30 November 2021
L 211130 NS NMA Covering Letter

**Wincote, Cow Lane, Steeple Aston OX25 4SG
Town and Country Planning Act 1990 Section 96A
Non-Material Amendment – Replacement of Basement and Provision of Bat Enclosure
On behalf of Mr. Henry Squire
Planning Portal Reference: PP-10433908**

Planning  
Proposed  
Basement Floor Plan

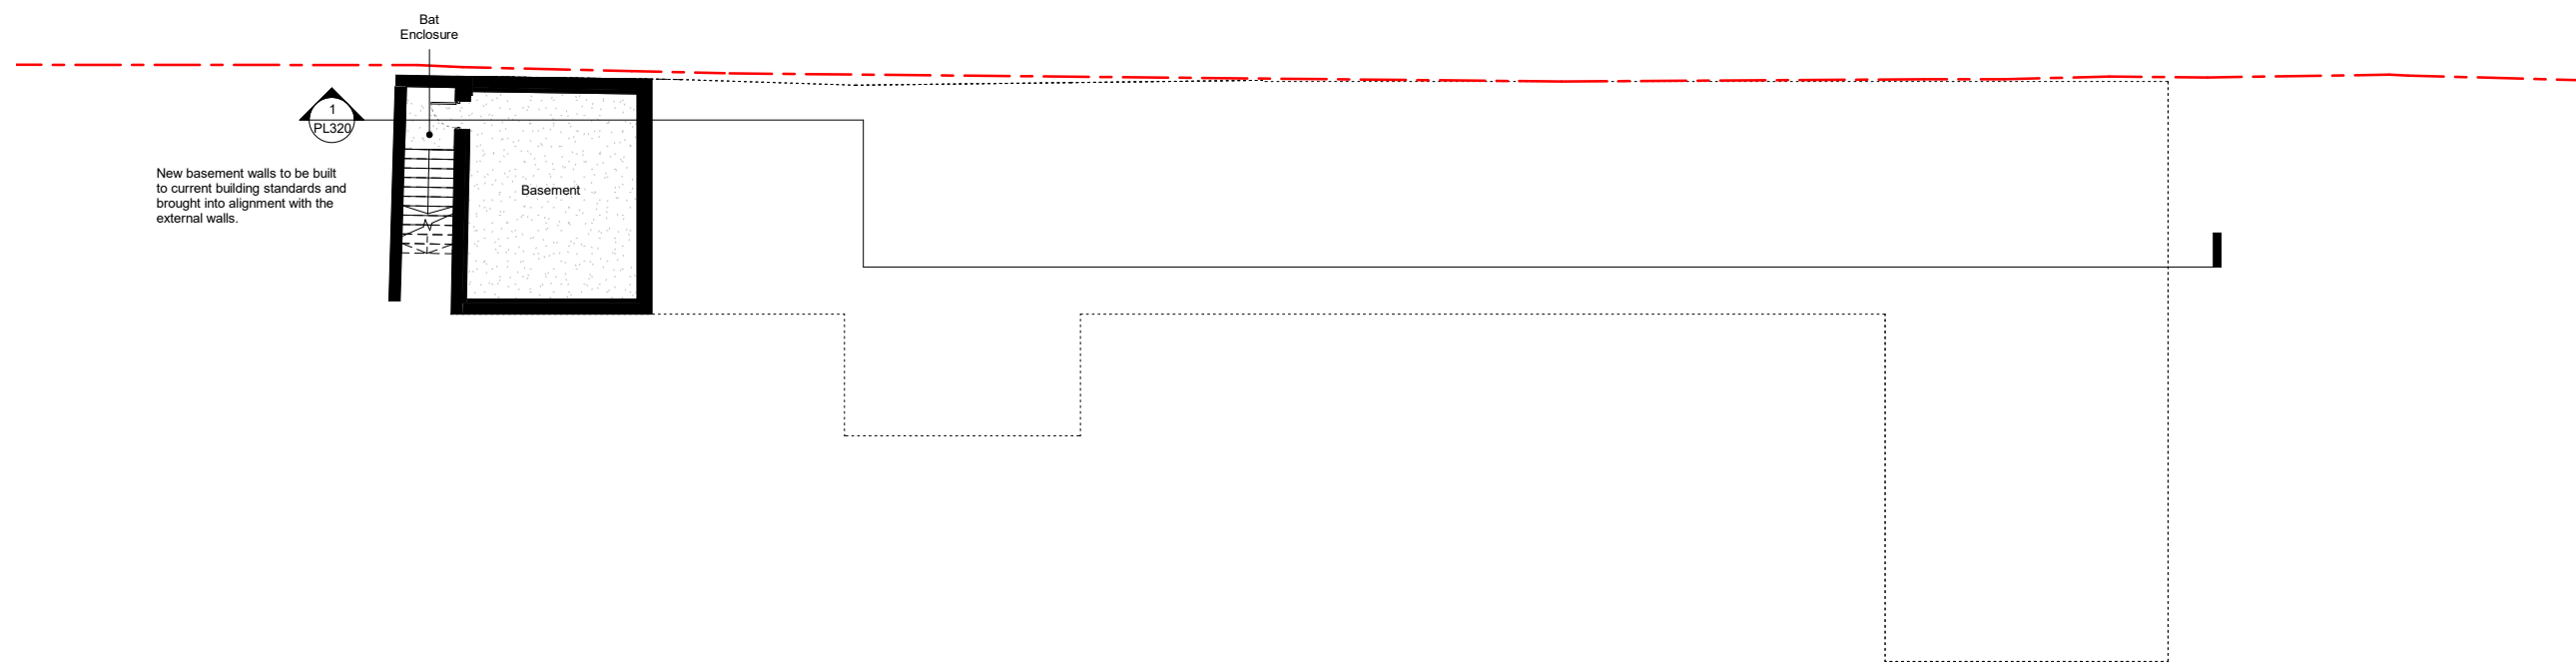
Replacement Basement: The changes to the existing basement are described in the Planning Addendum Summary which is submitted with the NMA. The new walls of the replacement basement will involve the north, west and east walls being rebuilt in the same position and the south basement wall being replaced 1 metre further out. This will increase the total floorspace by 3sqm. The new basement will also be dug 500mm deeper than the existing basement. In addition, the existing staircase which accesses the basement will be replaced in the same position as the existing one.

Planning
Proposed
Ground Floor Plan

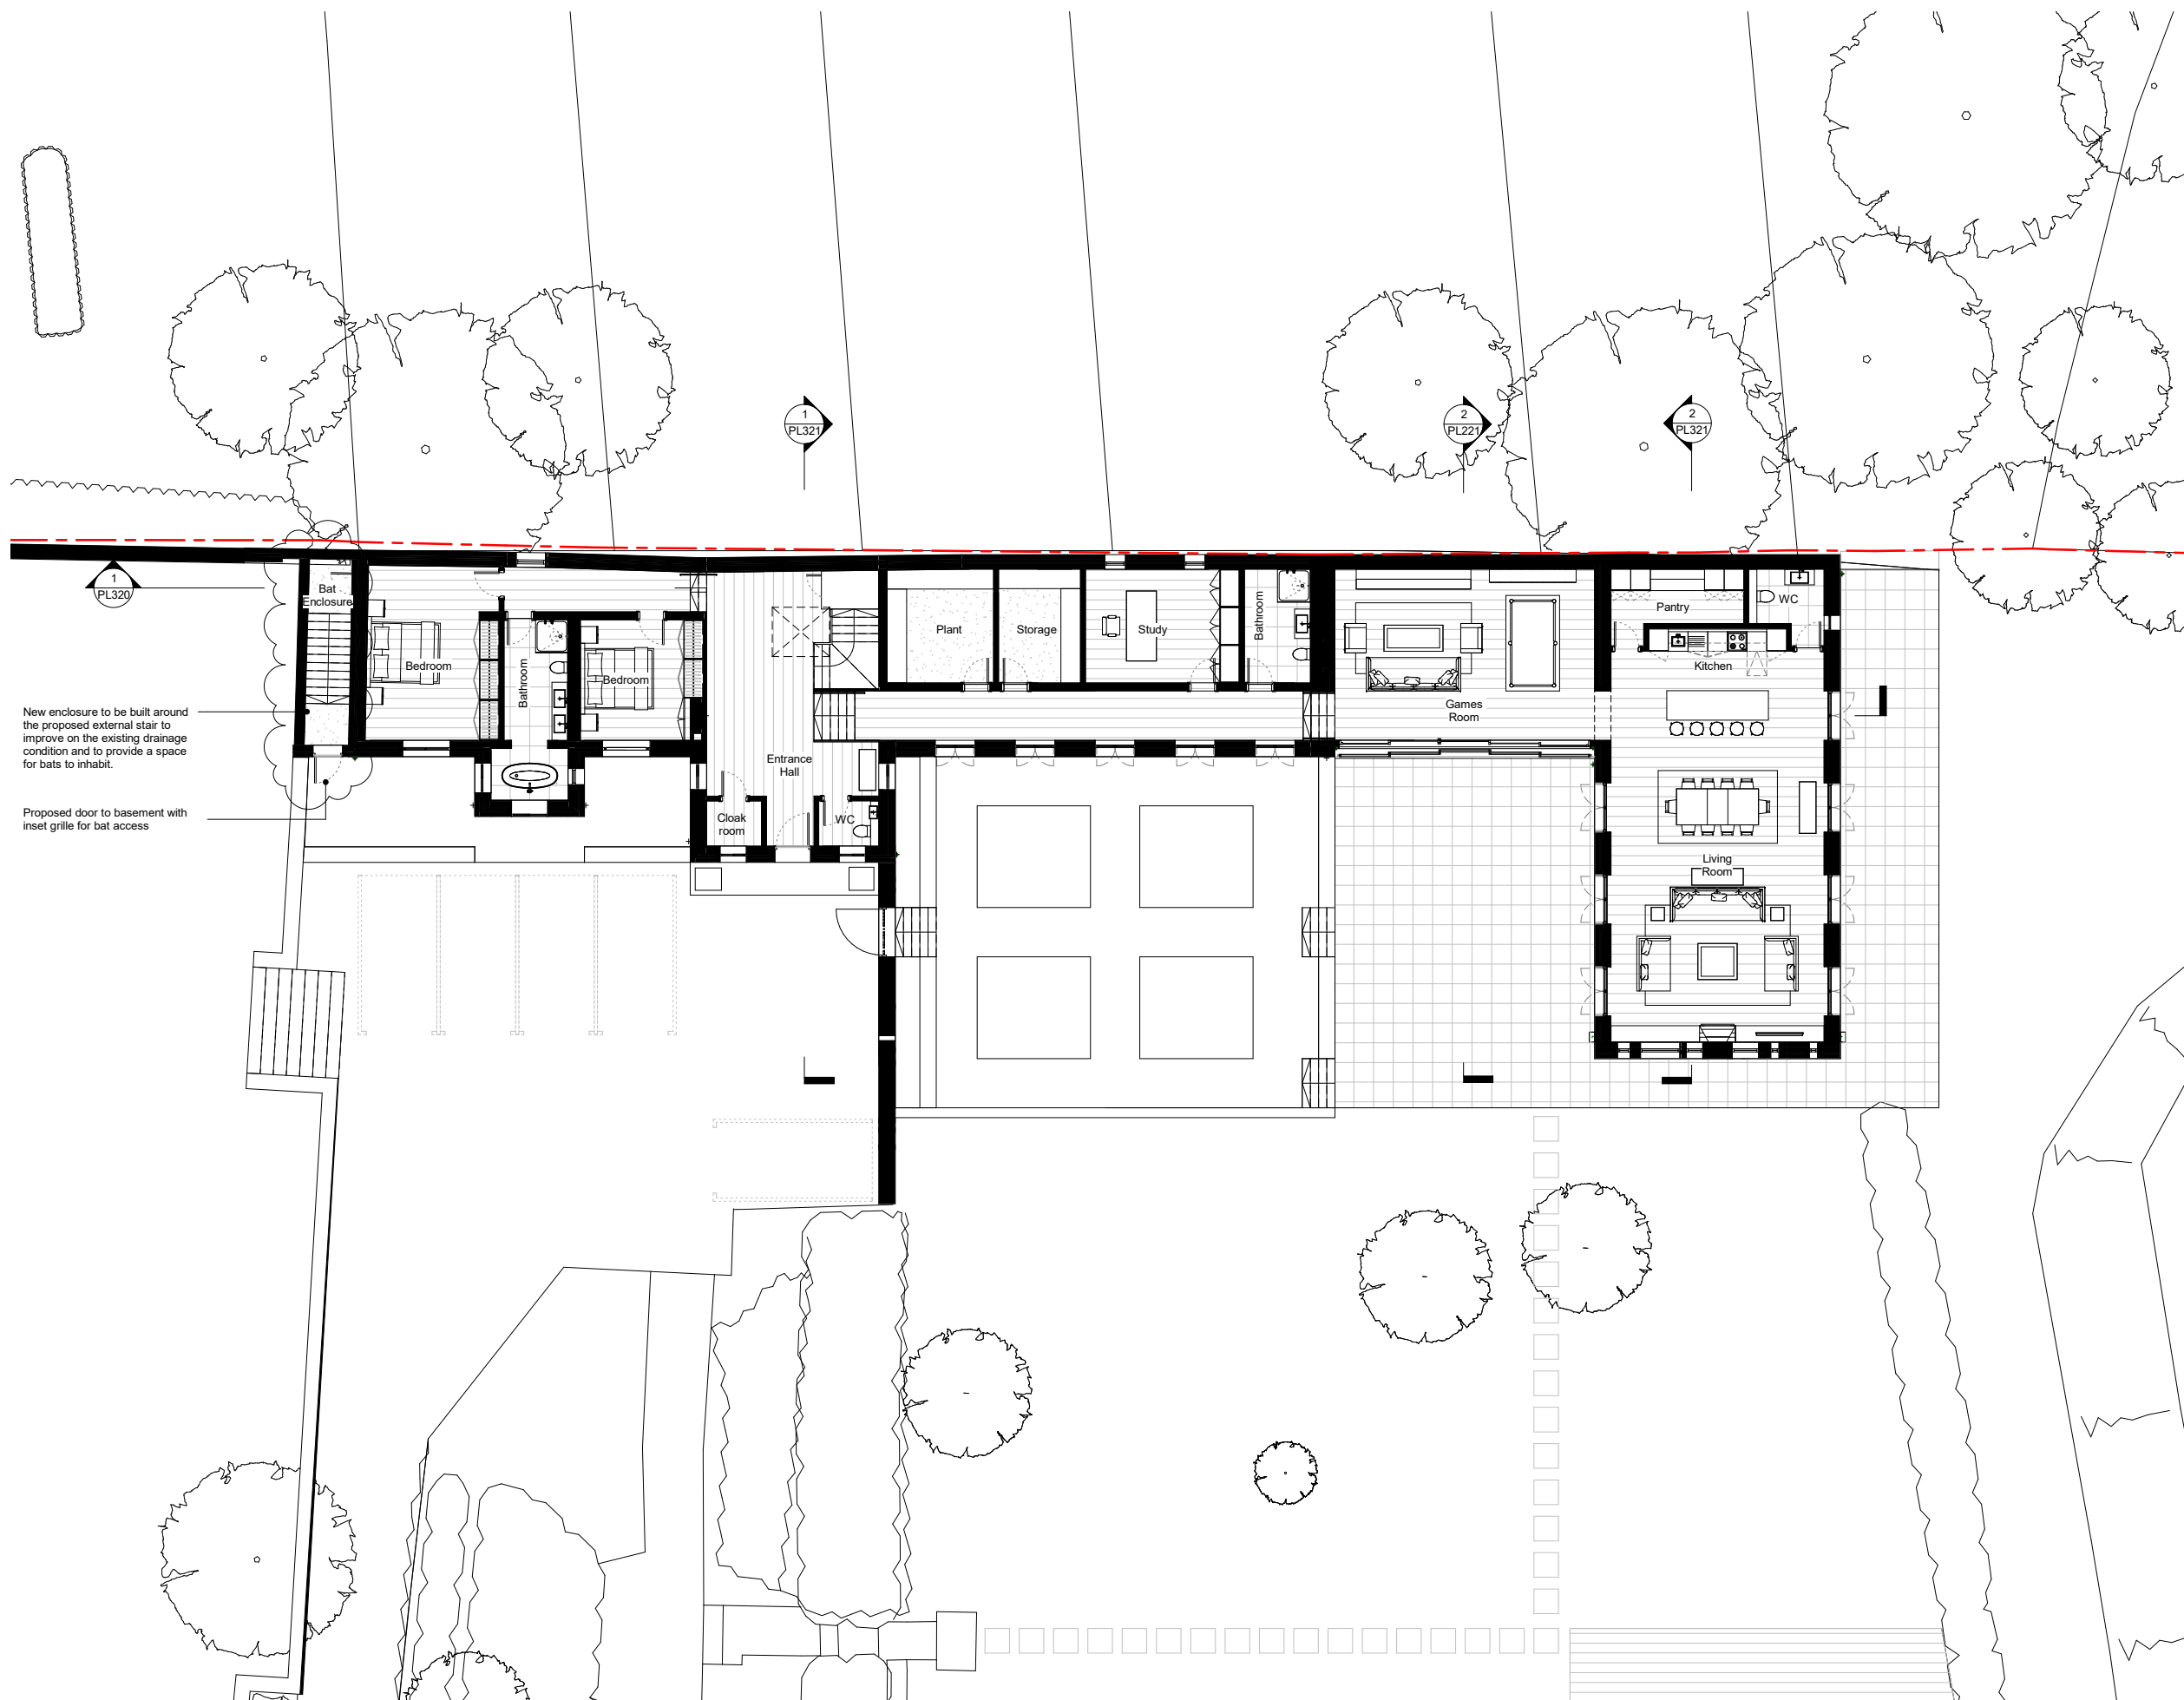
Bat Enclosure: The changes to create the bat enclosure are described in the Planning Addendum Summary which is submitted with the NMA. The new internal space will be fitted with a series of rough timber battens to provide crevice-dwelling opportunities for bats. As a result of the work proposed as part of this NMA a slightly larger area will be created for Natterer’s bats to inhabit.
